**REQUEST**

Current Zoning: R-9 (CD) (Single Family Residential, Conditional)  
Proposed Zoning: N2-A (CD) (Neighborhood 2, Conditional)

Approximately 19.16 acres located west of Nations Ford Road, south of Forest Point Boulevard, and north of Short Hills Drive.

The petition proposes a community of up to 72 multi-family attached residential dwelling units on a vacant, wooded property in the Nations Ford Road corridor.

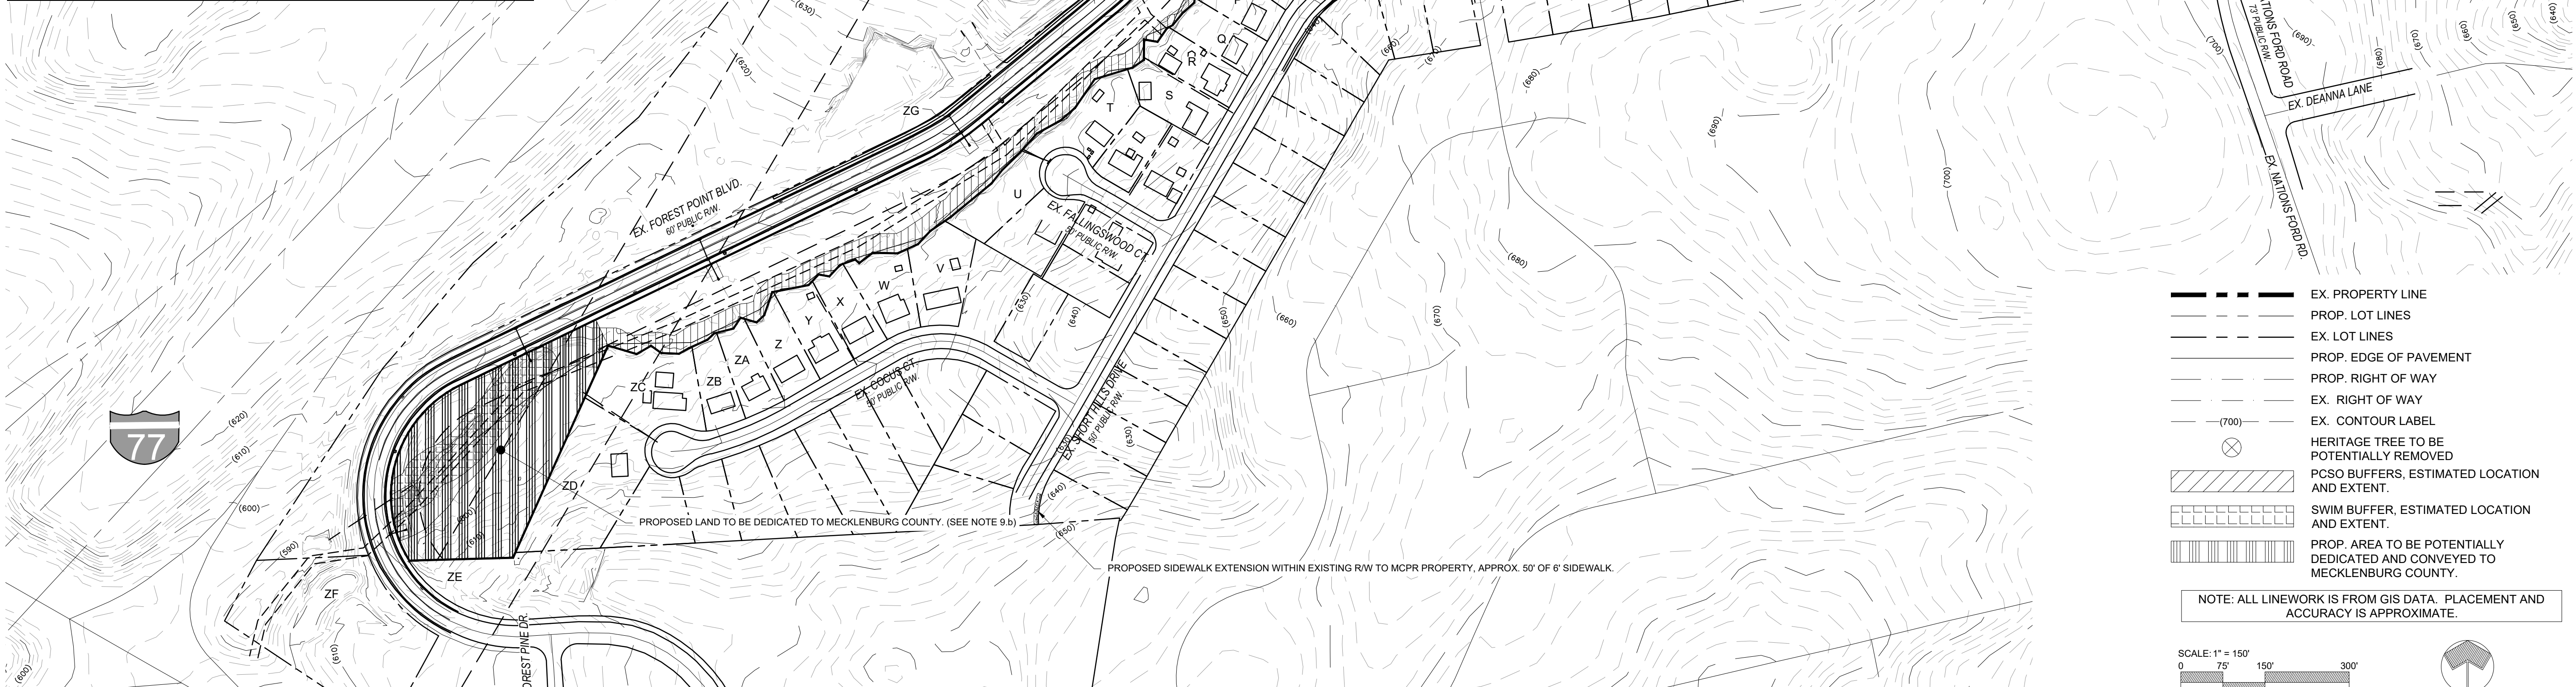
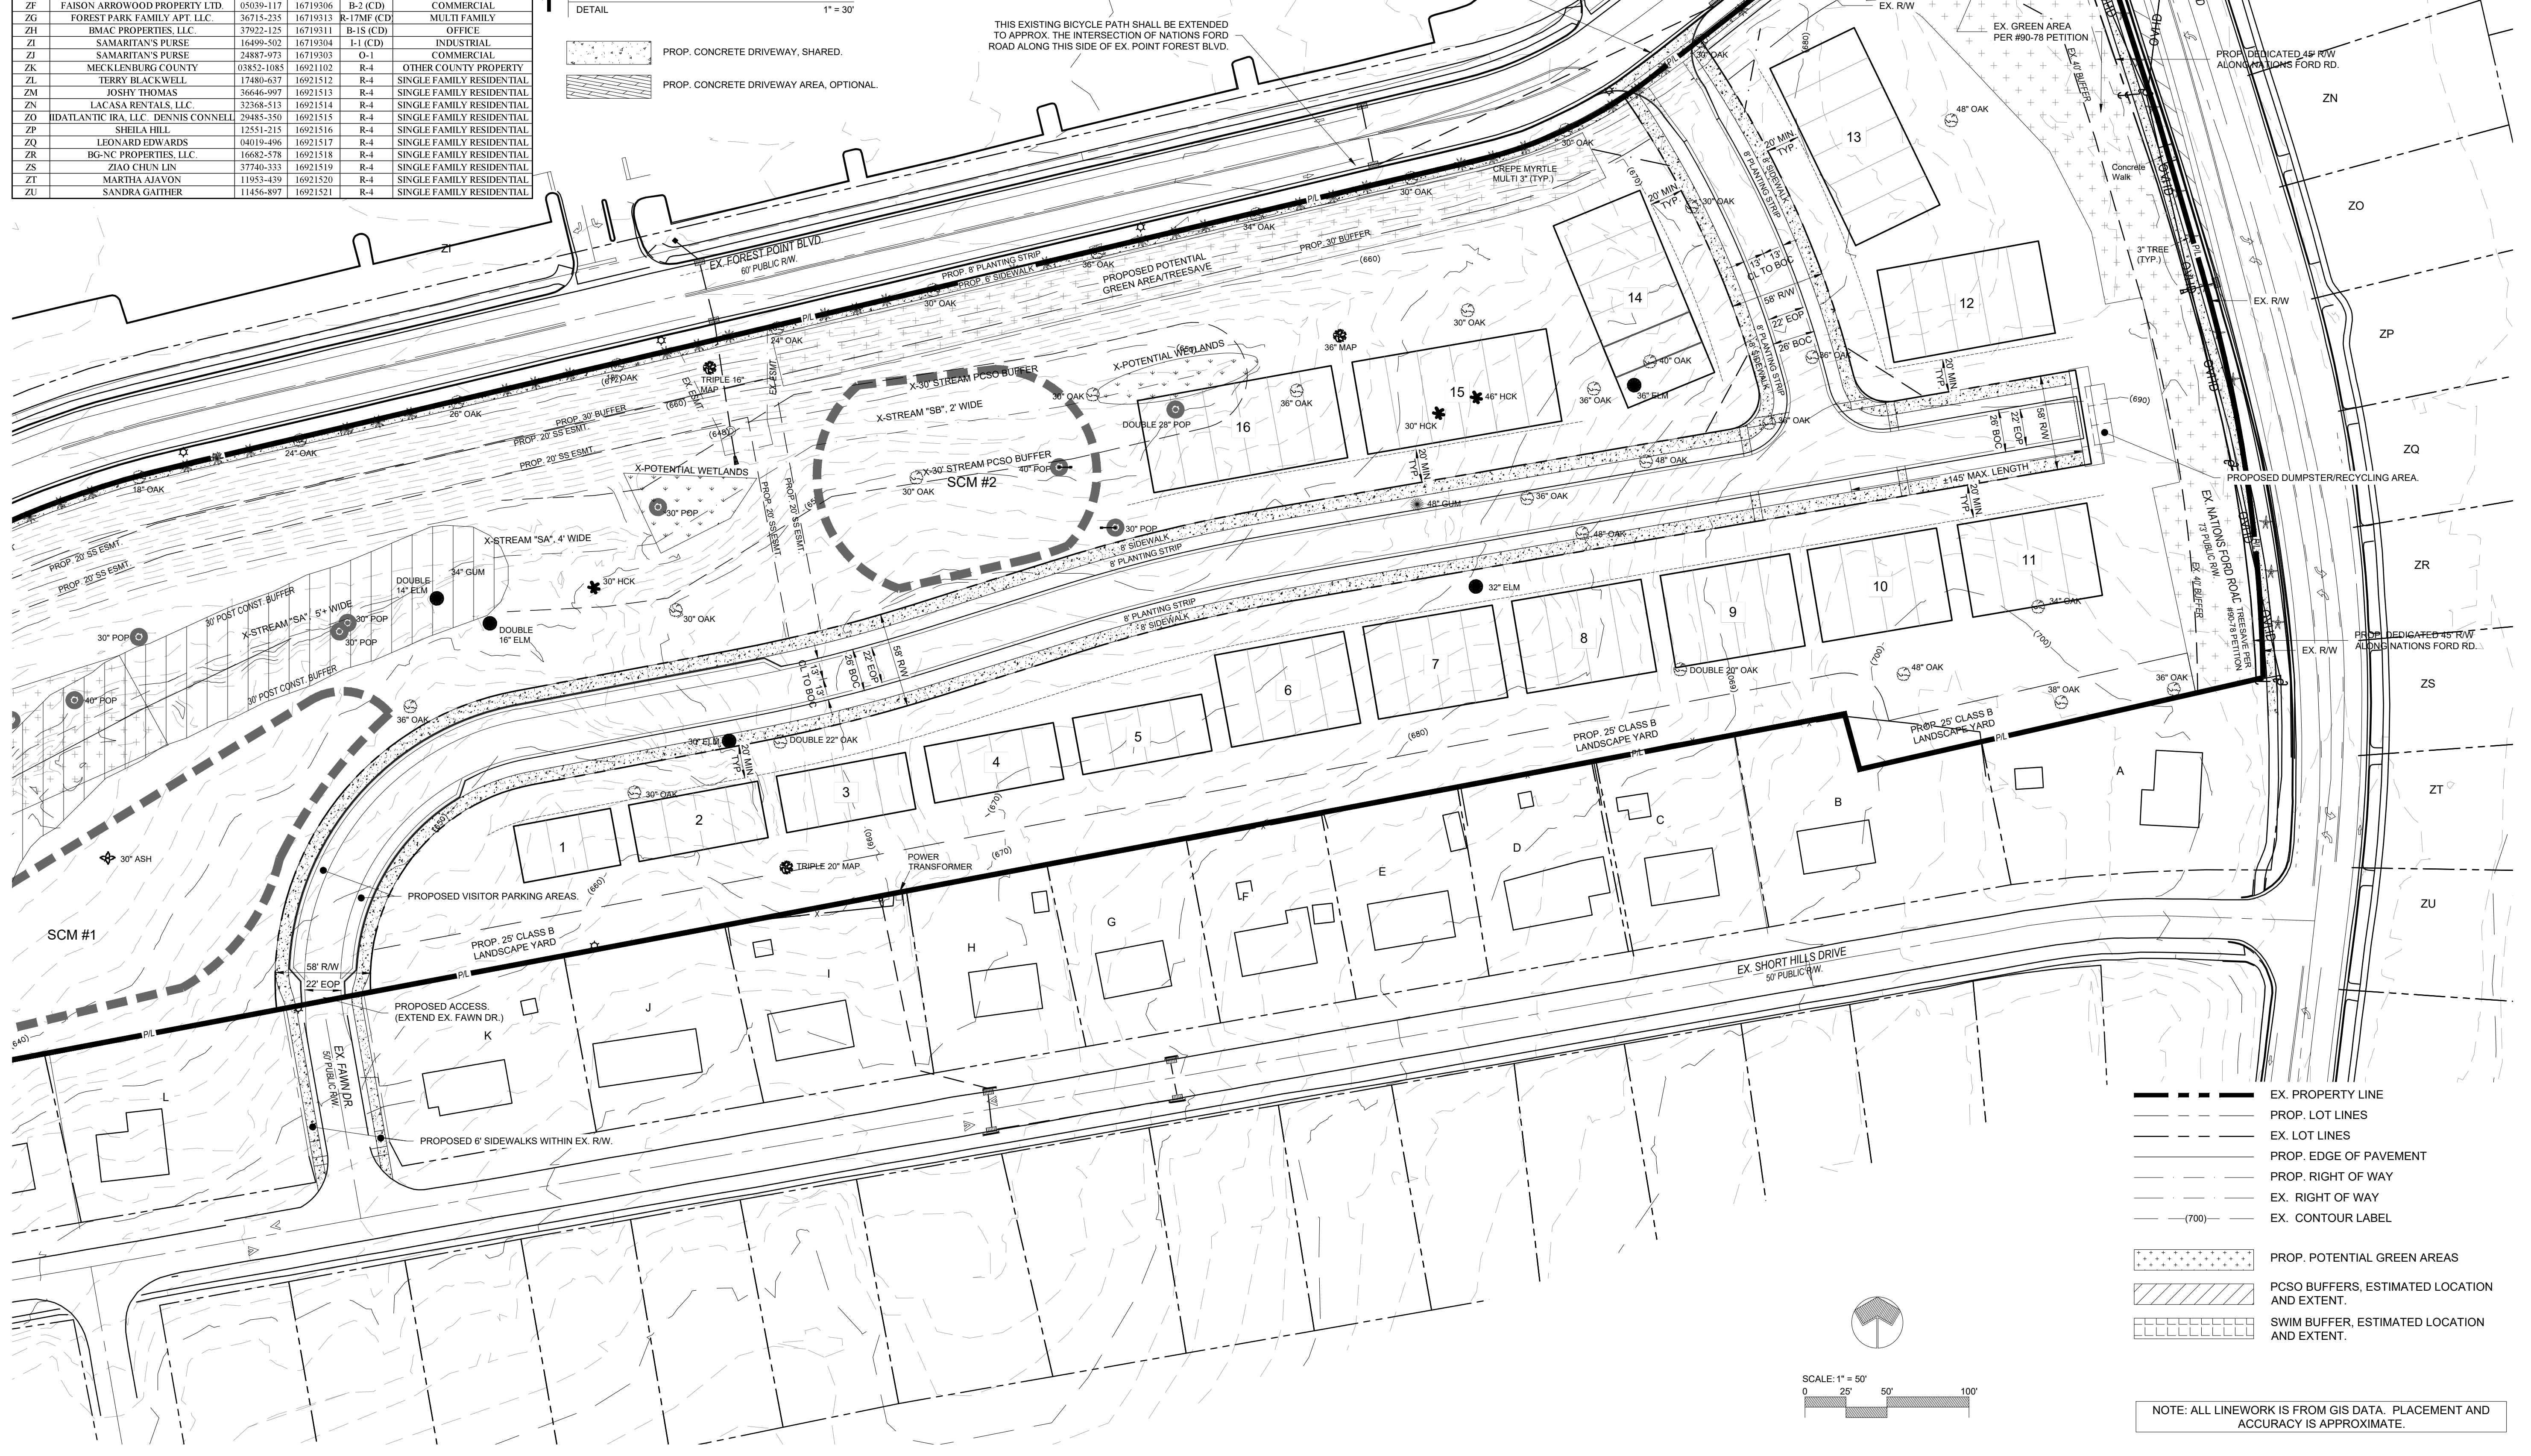
1. From the centerline of Forest Point, label and dimension the ROW and back of curb.
2. Edit note 5.f to reflect 50'x50' sight triangles as opposed to 35'x35'.
